City of Albuquerque Stormwater Construction Site Inspection Report

General Information					
ESC File No.	H20E003E	Project Name:	Starbucks Albuquerque		
NPDES Id. No.	NMIR10055D	Location:	2004 Wyoming		
6/10/2024	Owner	Contractor			
Operator	WFC Wyoming NM LLC				
Contact name & title	Renaldo Gallagher				
e-mail	rgallagher@westfin.com				
Contact Phone #	770-344-8962				
COA Inspector	Chancellor English	Start/End Time:	12pm		
Construction Phase:	verticals, utilities				
Type of Inspection:	Regular	Storm Event	Post Storm Event >0.25"	311/Complaint	Follow Up
Weather at time of inspection?	Clear		Temperature: ~	40	
Estimated date of last storm 0.25" or greater	6/10/2024

SHEET NUMBER
L1.0

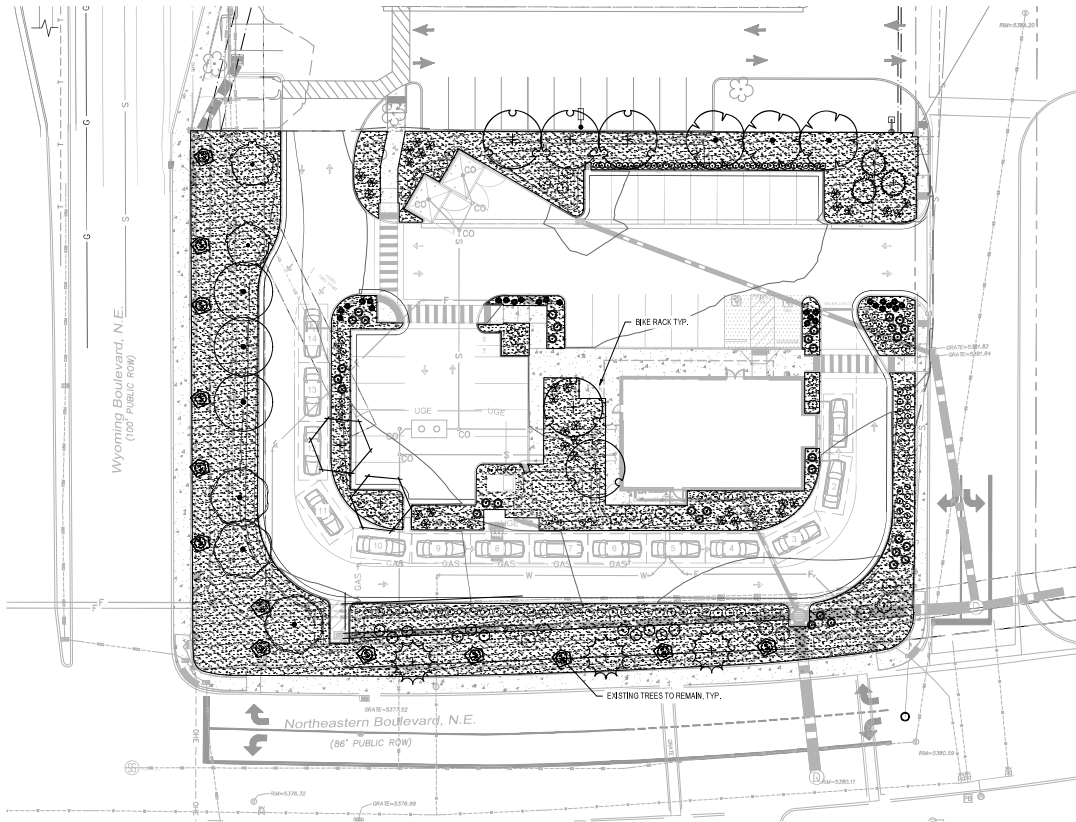
Item Number	Deficiency/ Corrective Action				
1	Your permit coverage posting was missing from your site in violation of CGP Part 1.5. Required mitigation: You must post a sign or other notice of your permit coverage at a safe, publicly available location in close proximity to the construction site. The notice must be located so it is visible from the public road that is nearest to the active part of the construction site per CGP Part 1.5				
2	The SWPPP Inspector and SWPPP Preparer need to be identified by name in violation of CGP Part 7.2.2. The self-inspection reports were unavailable at the time of inspection in violation of CGP Part 4.7.3. Stabilization practices are not identified in the SWPPP in violation of CGP Part 7.2.6.b.vii. Required mitigation: Identify the personnel (by name and position) that you have made part of the stormwater team pursuant to CGP Part 6.1 per CGP Part 7.2.2. You must keep a copy of all inspection reports at the site or at an easily accessible location, so that they can be made immediately available at the time of an on-site inspection per CGP Part 4.7.3. You must include the specific vegetative and/or non-vegetative stabilization practices and the stabilization deadline that will be met in accordance with CGP Part 2.2.14 per CGP Part 7.2.6.b.vi. The addition of the Landscape Plan will satisfy this issue.
